Please ask for: Sian Eggington
Email: sian.eggington@terraquest.co.uk
Telephone: 0121 2341390
Our Ref: BE/59/20/A
Your Ref:
Date: 8th July 2020

Application for Consent to Display an Advertisement(s)

Development: See Application Form
Location: Land At Phase 1a Oldlands Farm Bognor Regis PO22 9NN

Drawing Title:
PROPOSED SHARED ESTATE
TOTEM SIGNAGE

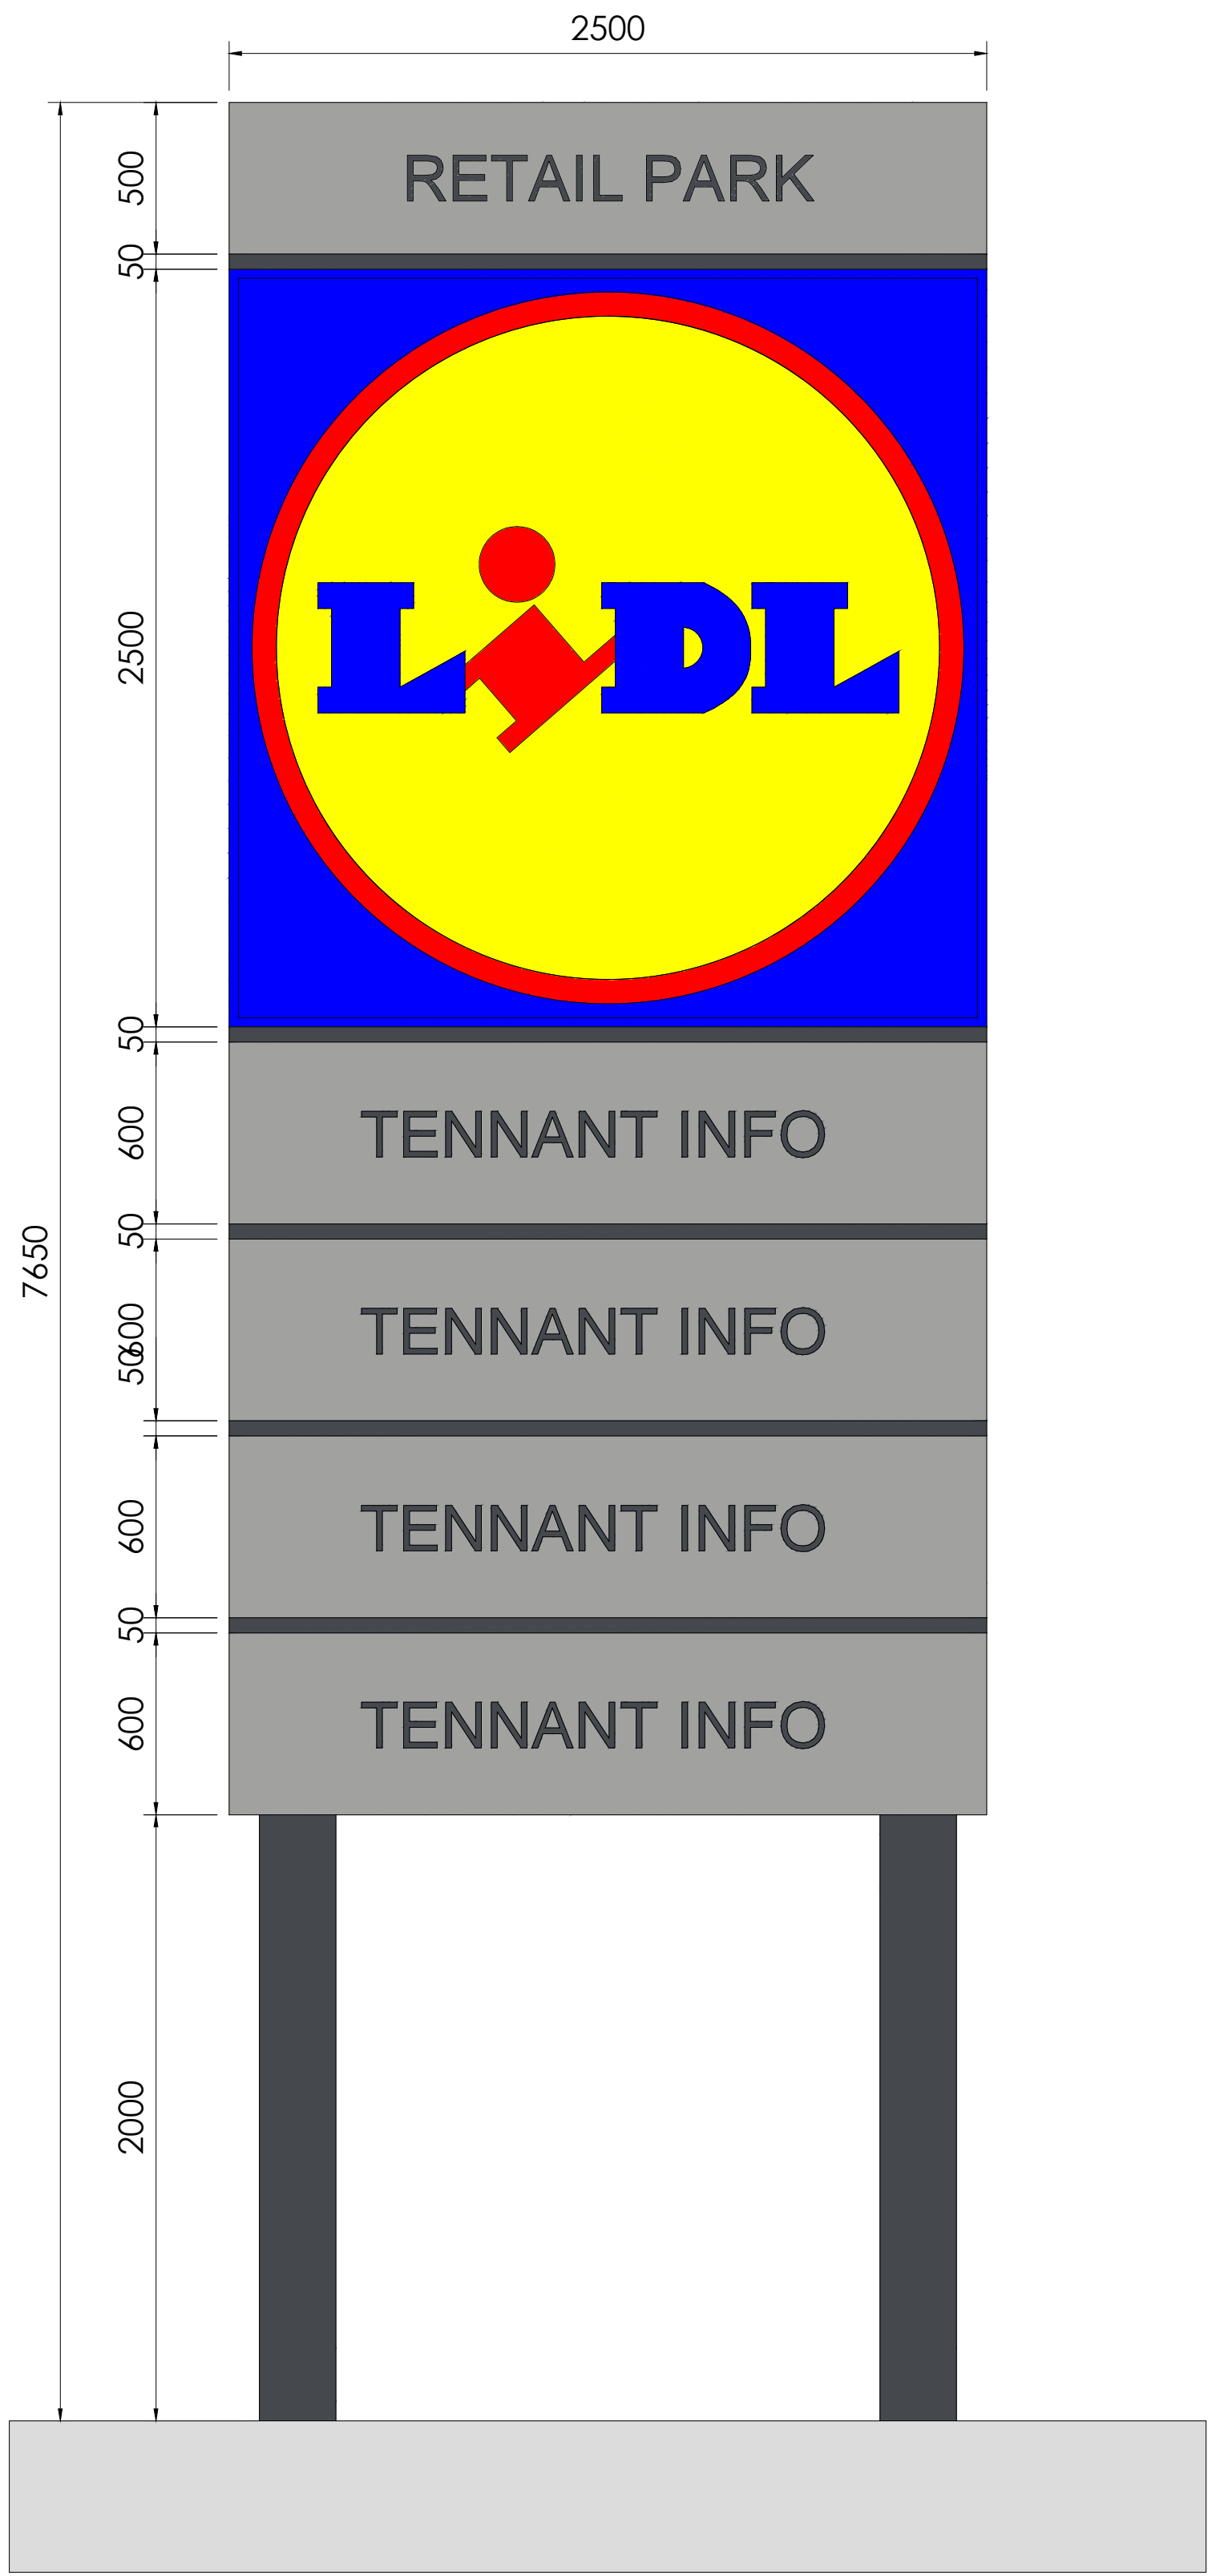
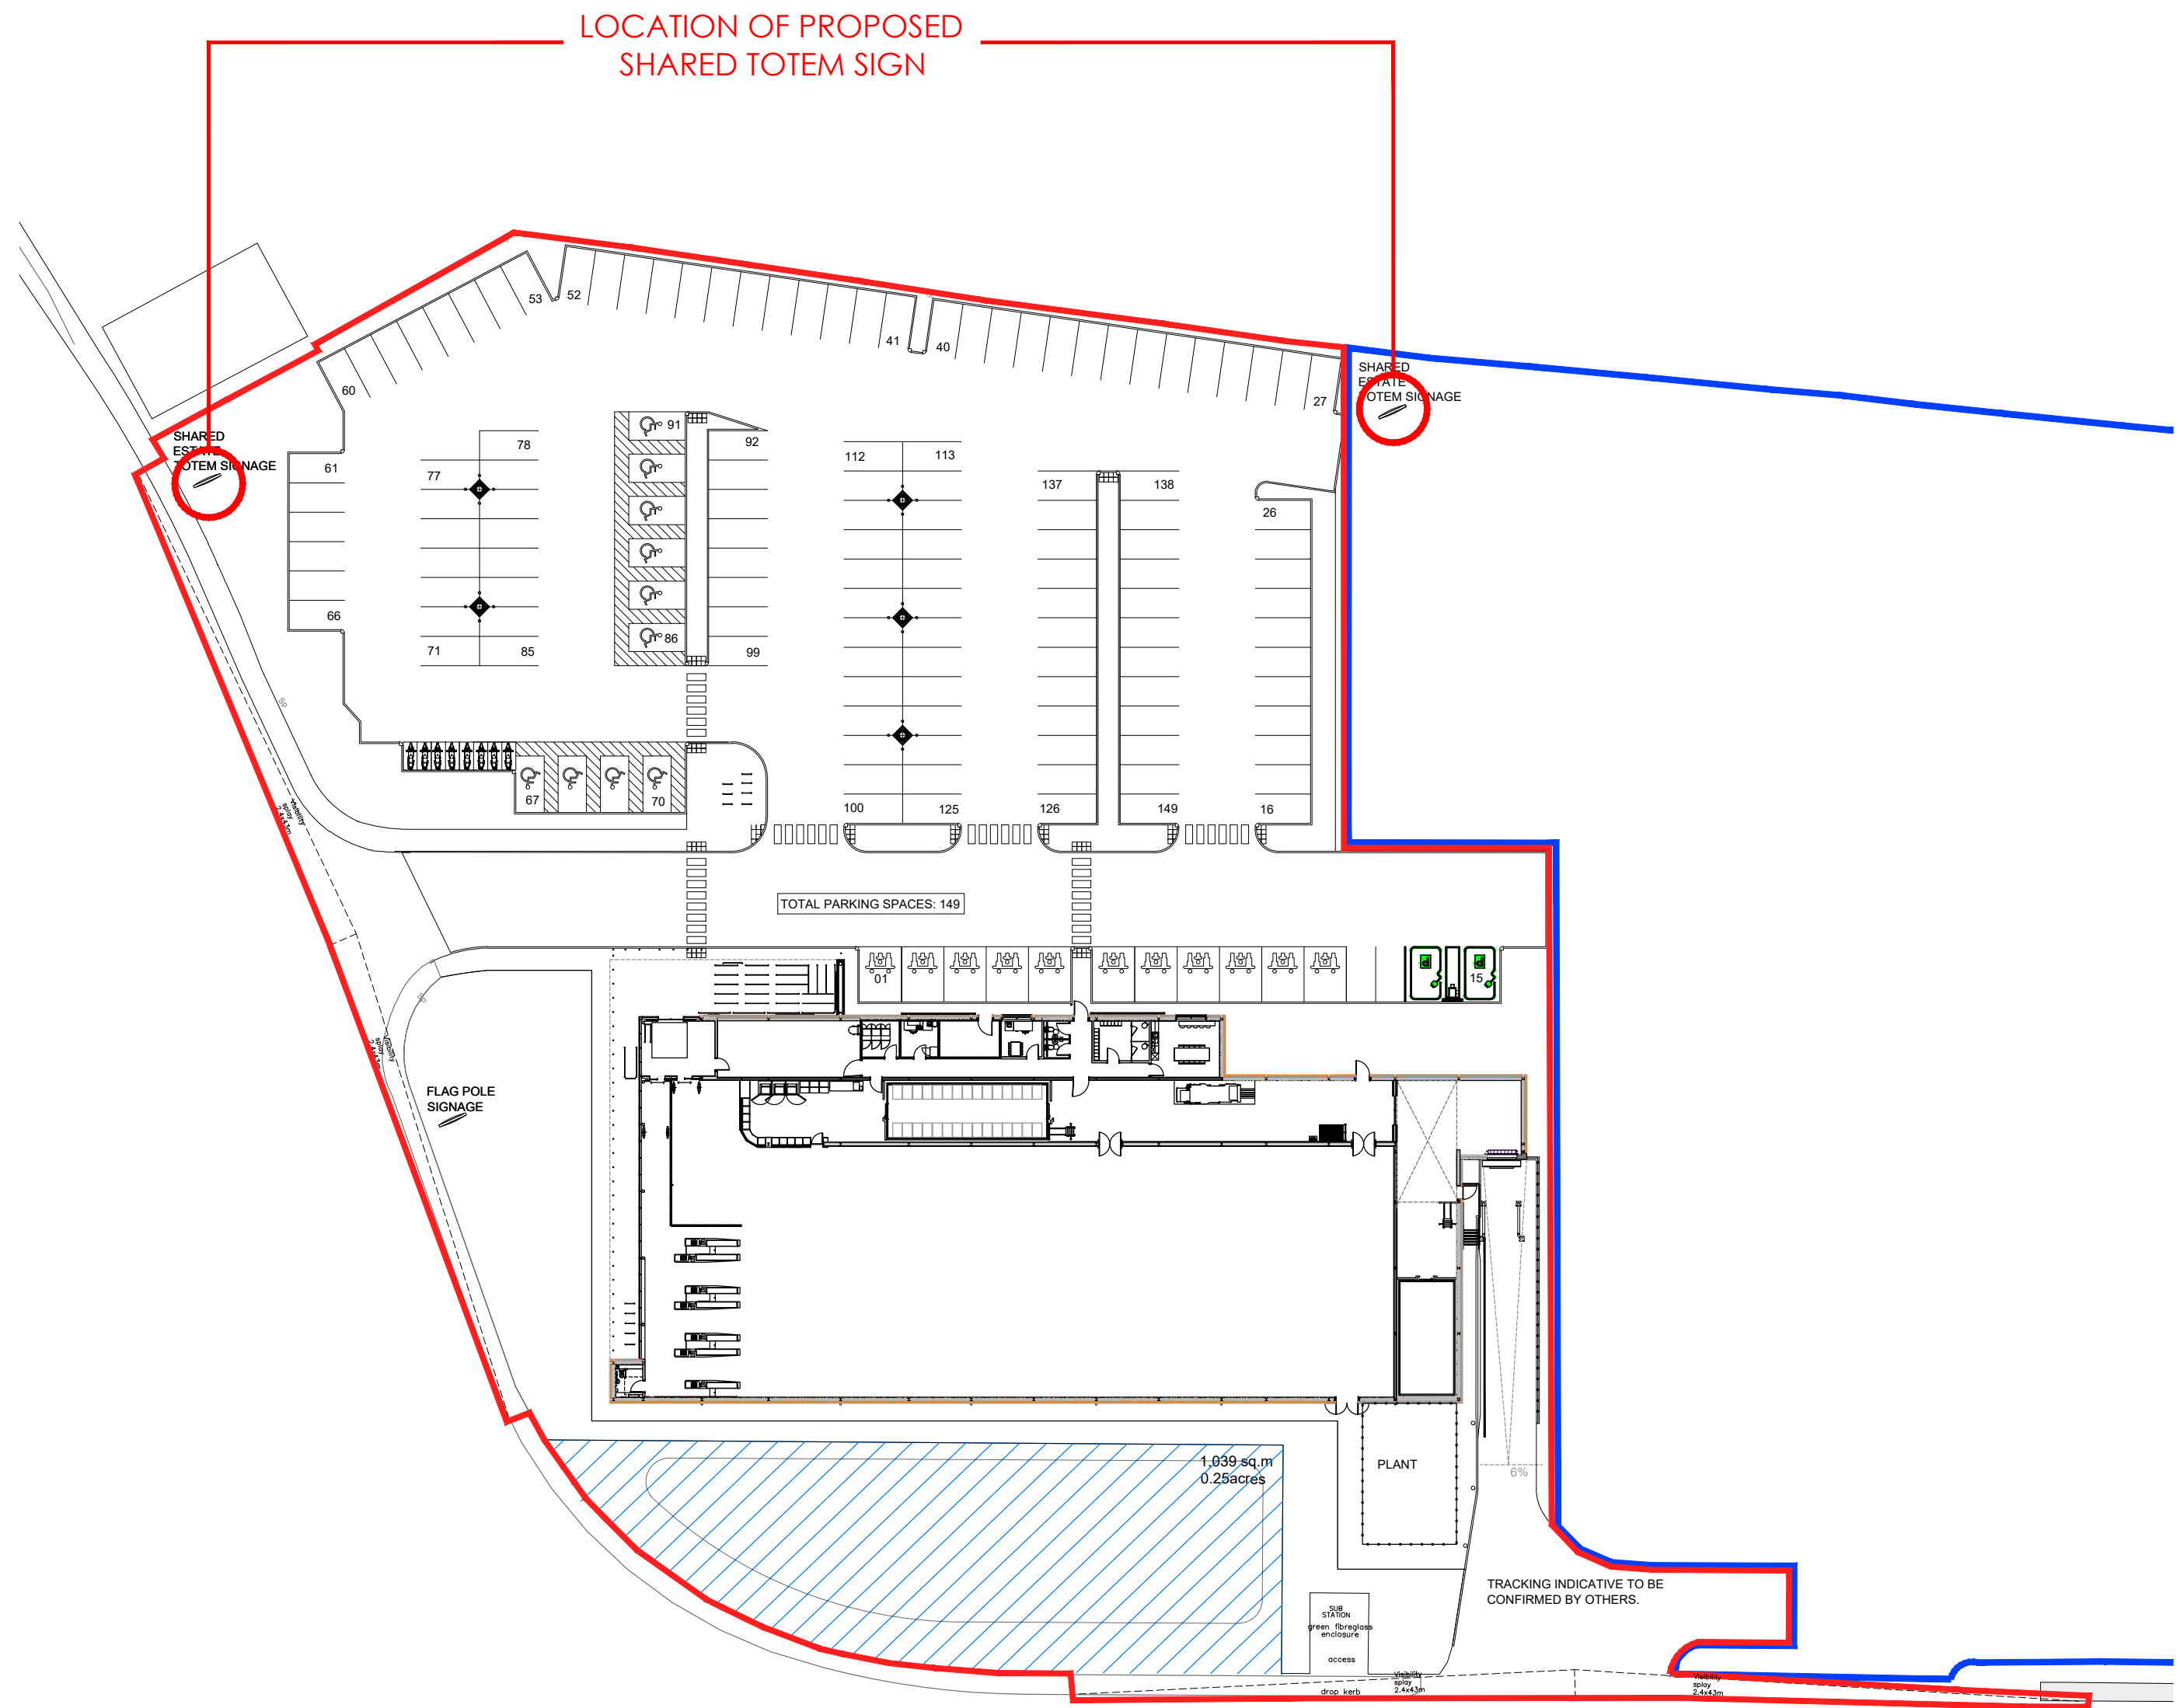
Totem: The totem height from the ground should be 2m not 0. With your permission we can amend this for you.

Advert: The measurements on the plans do not match the measurements on the forms. Please amend.
